This feedback has been produced by Lincolnshire County Council Sustainable Travel Officers with a view to address the walking, wheeling and, cycling aspects in response to the proposed residential development **Land to the west of Monks House Lane, Spalding, PE11 3LH** submitted for comment.

Date: 25.07.2025
Planning Application No: H16-0584-25

Image 3.2 – Site Location: Local Context

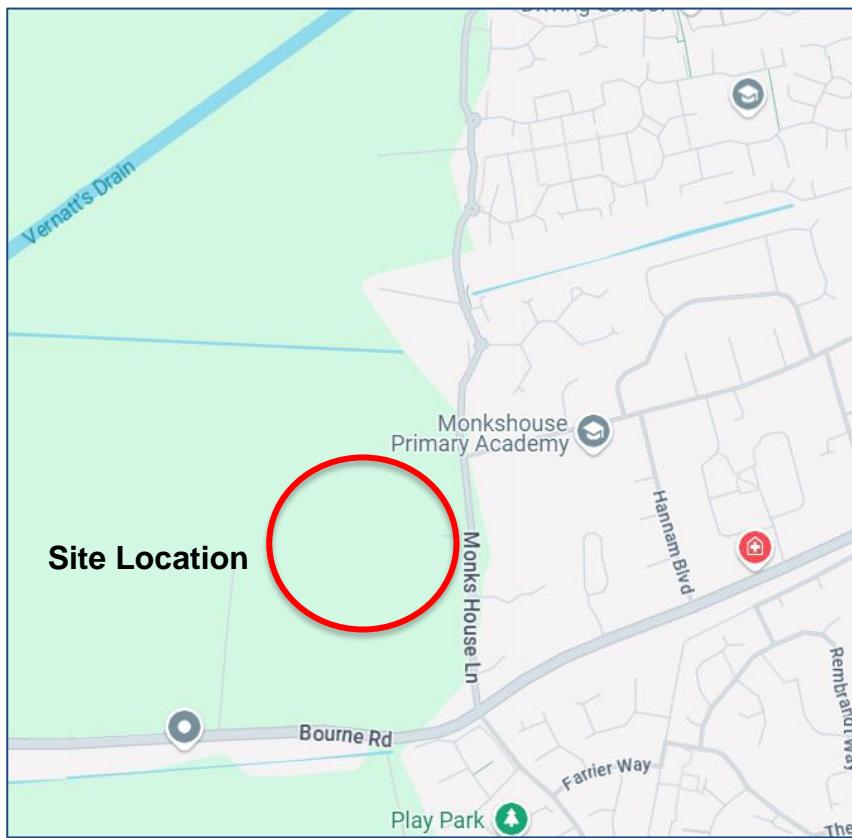
2.3.12	Local Transport Facilities, Walking	Clarity is required in identifying the PROW and footpaths in Figure 2.5. Which routes support pedestrians into, through and out of the proposed site? Has an accessibility been considered when promoting the viability of the access points to the site? Will people with mobility aids, wheelchair users or prams be able to utilise these for utility purposes?
